Ms Nicola Curtis
Principal Mining Approvals
Illawarra Coal Holdings Pty Ltd
Innovation Campus Enterprise 1 Building Level 3 Squires Way
NORTH WOLLONGONG NSW 2000

08/11/2021

**REQUEST FOR INFORMATION No. 4
APPIN MINE VENTILATION AND ACCESS PROJECT (08_0150 MOD 3)**

**Figure 1: Noise Monitoring Locations and Sensitive Receivers**

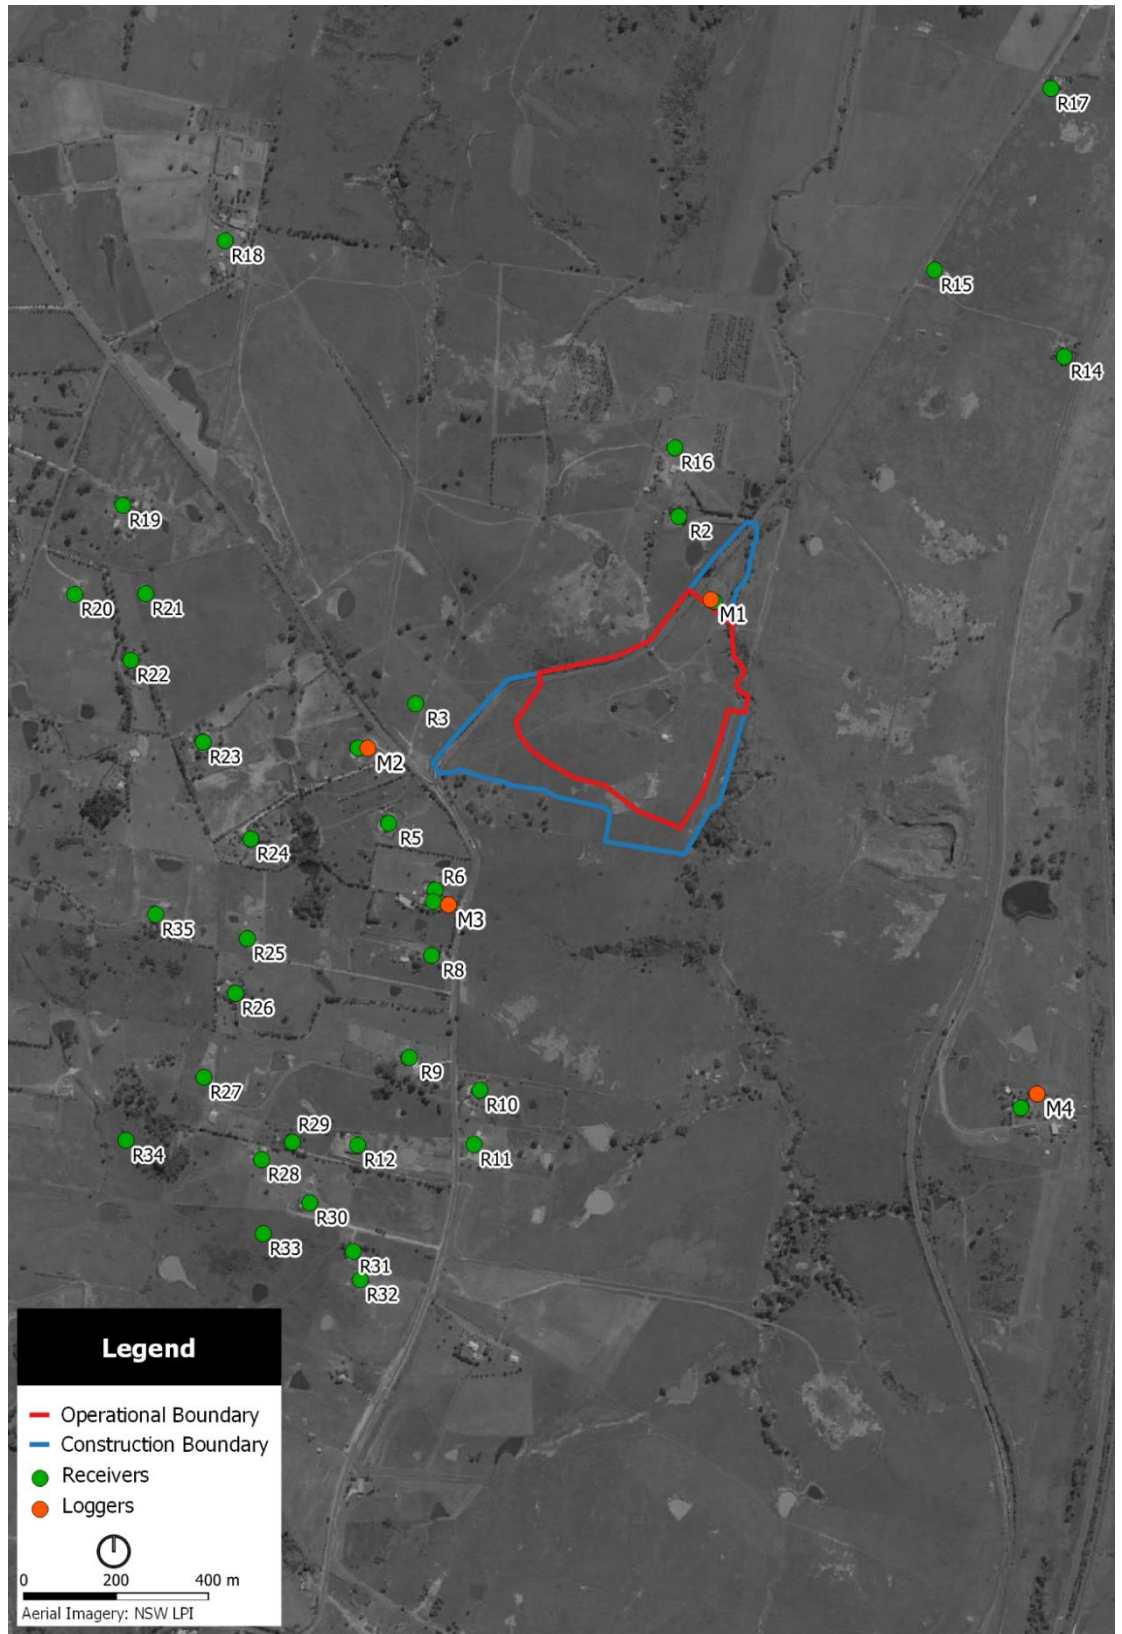
The *Noise and Vibration Impact Assessment* (NVIA) (Wilkinson Murray, June 2021) indicates that background noise monitoring was undertaken at the four locations representing the “most potentially affected sensitive receivers near the Site”. However, the Department notes that background noise monitoring was not undertaken at the nearest affected premises (NAPs) to the site (ie. R2 or R3).

The Department considers that background noise monitoring undertaken at M2 and M3 are likely to have been influenced by traffic noise at the Finns Road and Menangle Road intersection and traffic along Finns Road (south) (refer to Figure 5 of the NVIA). Noise at location M4 would be heavily influenced by traffic noise along the Hume Motorway. M1 is considered to be most representative of NAP background noise levels, however may also be influenced by traffic noise along Menangle Road when compared to R2 or R3 which are both set further back from the road.

The Department requests further justification for conducting background noise monitoring at these locations, and implications for noise predictions associated with the project considering the above.

### Concept Site Design - Indicative Dimensions Appin Mine Ventilation and Access Project

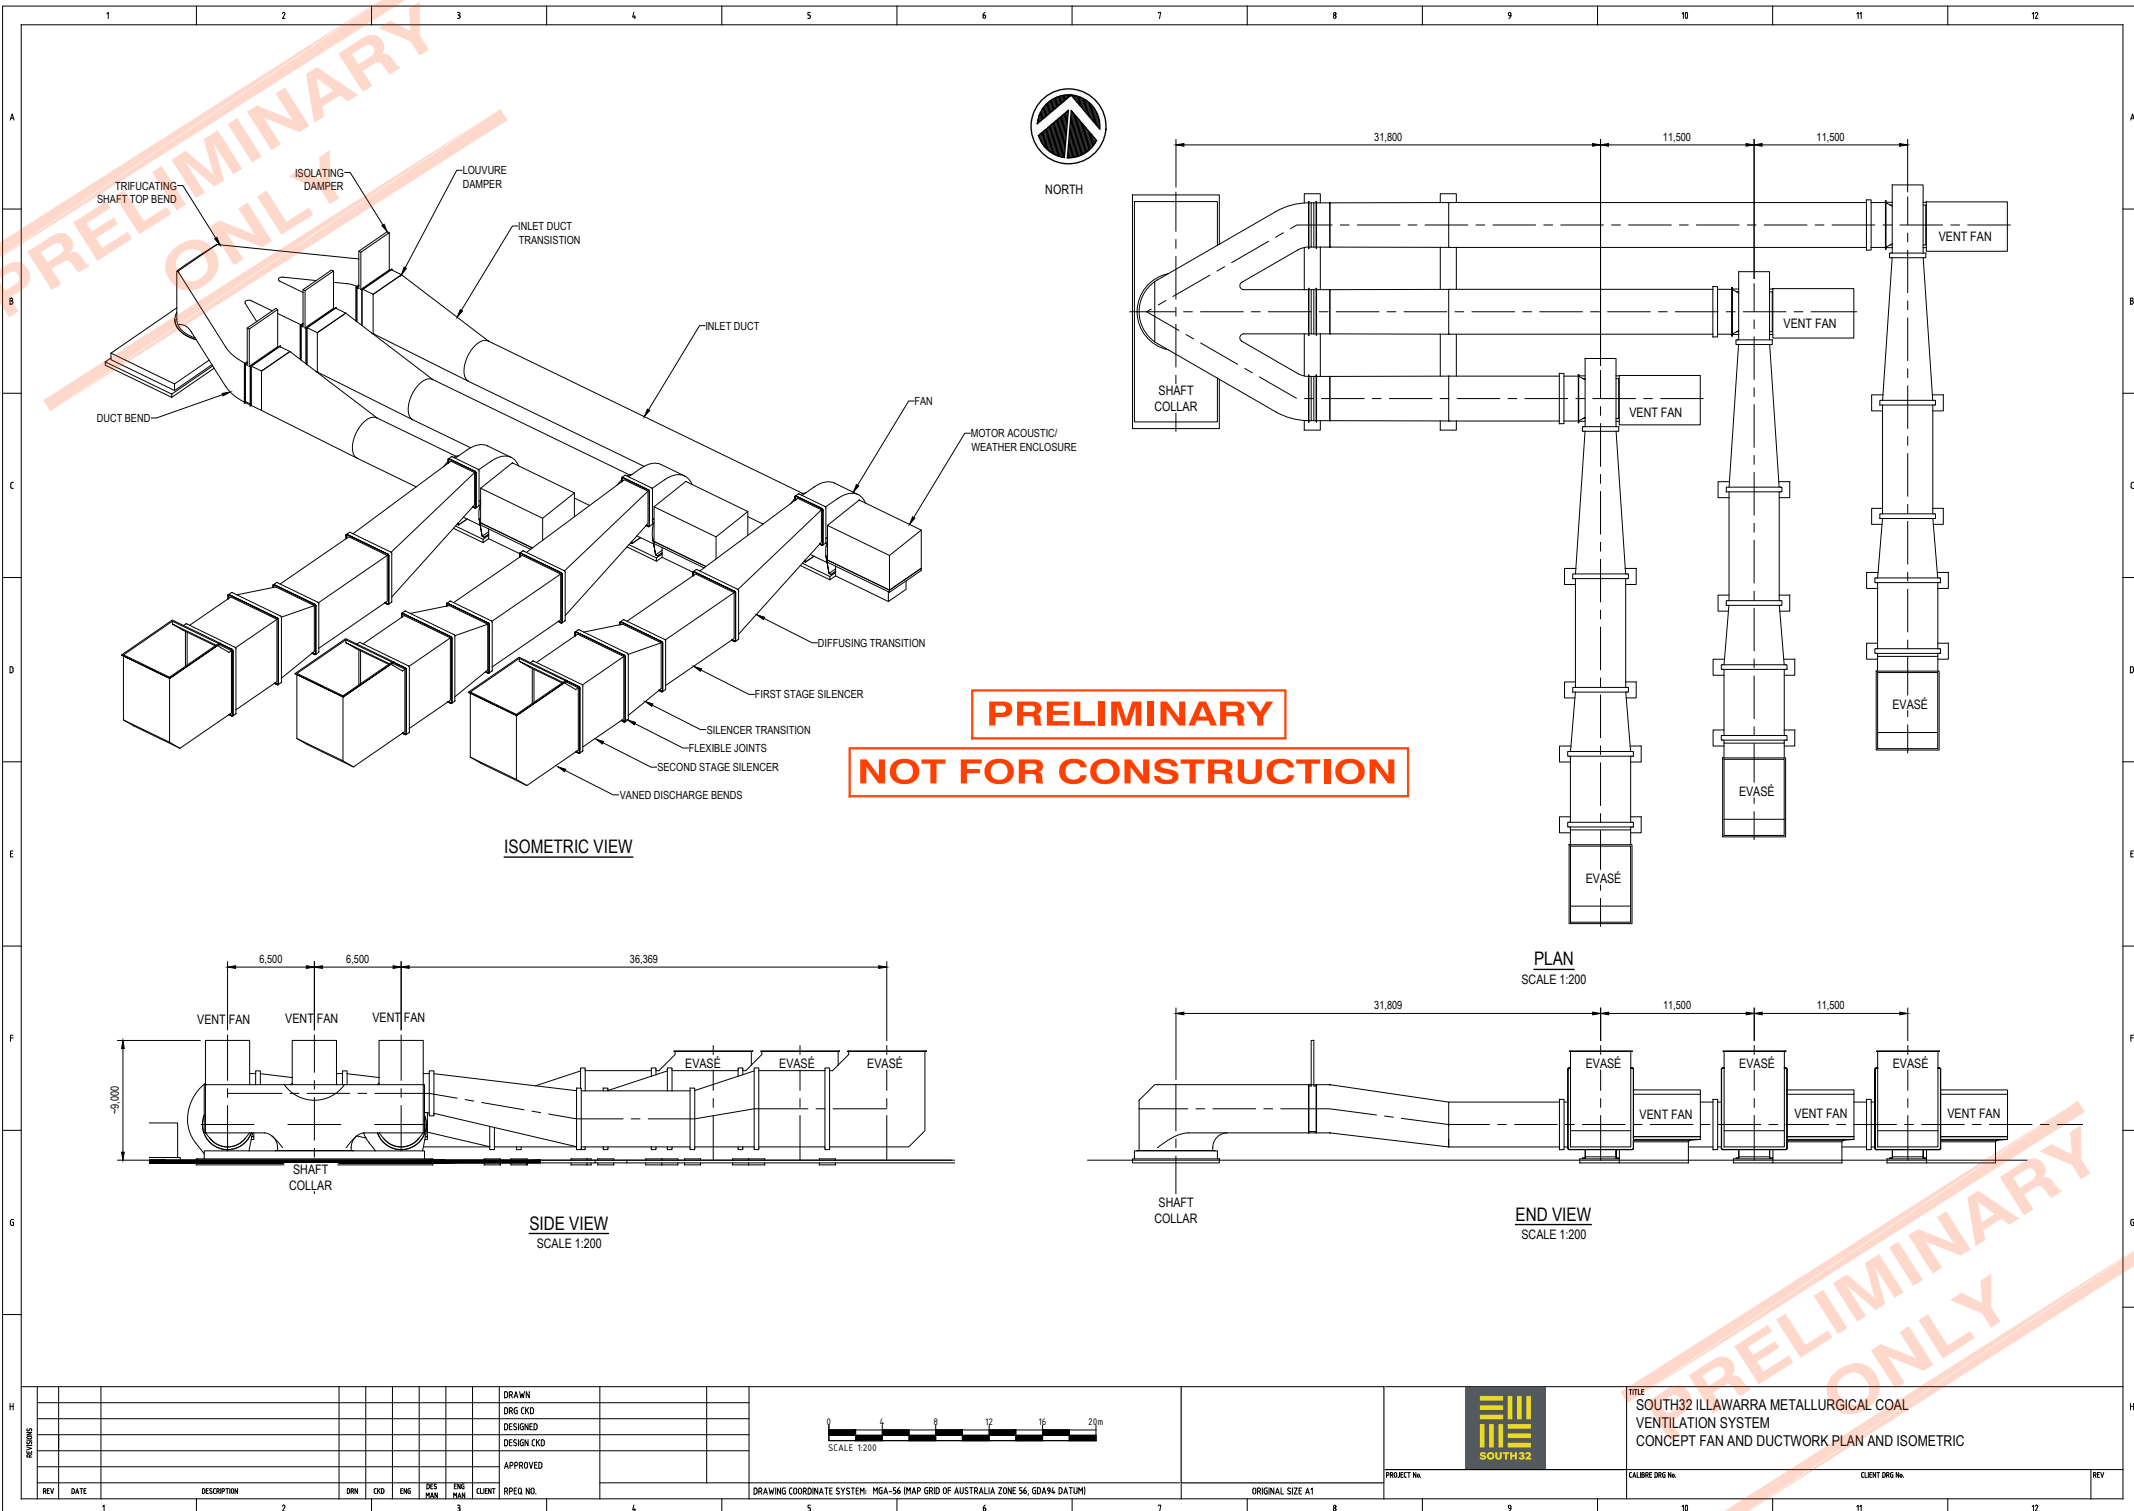
The Modification Report does not include schematic diagrams of key surface infrastructure and buildings showing dimensions, making it difficult for community members to understand the dimensions (height and width) of the surface infrastructure and buildings in the landscape. The Department notes that schematics of VS7 shown in Figures 3-14, 3-15 and artist impressions in Figure 3-16 and 3-18 do not include dimensions.

The Department requests more detailed concept designs of key surface infrastructure be provided, including dimensions.
